CITY OF PORTLAND, MAINE
HISTORIC PRESERVATION BOARD

May 15, 2017

Re: ~~86~~⁵⁶⁻⁵⁸ Exchange Street – Window replacements
CBL: 032 I002

This office has approved your application to replace 24 existing windows and repair the stucco on the front facade at 58 Exchange Street. Approval is based on the specifications and information provided with the application dated May 5, 2017, and is subject to the following conditions:

56 Exchange St.  
Portland, ME

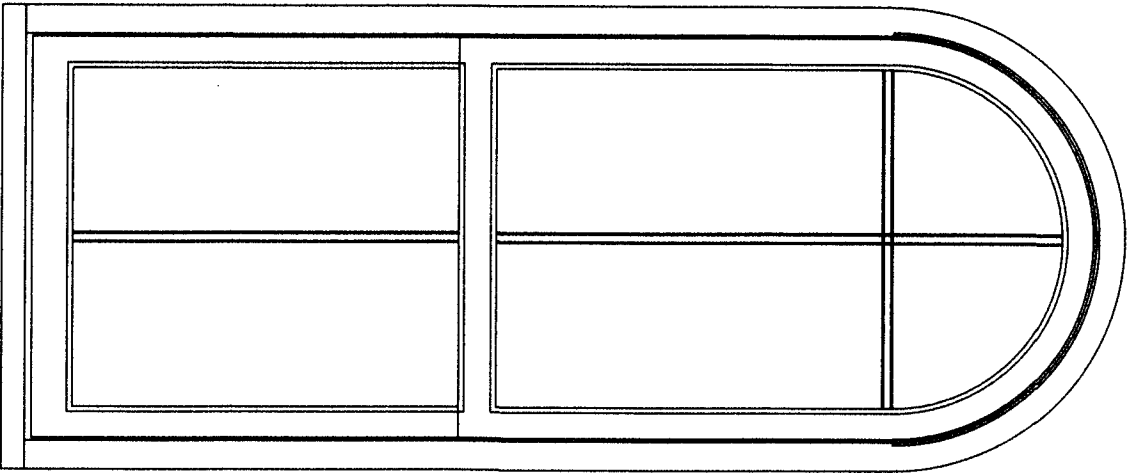
1. HP staff understands the 24 new windows are to be wood, full-units by Norwood, built to drawings dated 4/28/17 and specifications dated 5/2/17 provided by Matthews Brothers. Proposed windows and exterior trim are understood to be a close visual match for the existing windows.
2. Glass size in the proposed windows is understood to be a close equivalent to the existing windows.
3. Glass is to appear clear, non-reflective, and non-tinted, with a minimum visual transmittance of .7.
4. If screens are desired they are to be half screens.
5. Masonry contractor is to contact HP staff for review and approval of stucco samples prior to undertaking the stucco repair project.
6. HP staff understands the existing, obsolete light fixture projecting from the middle of the front façade is to be removed during the course of the work in 2017.
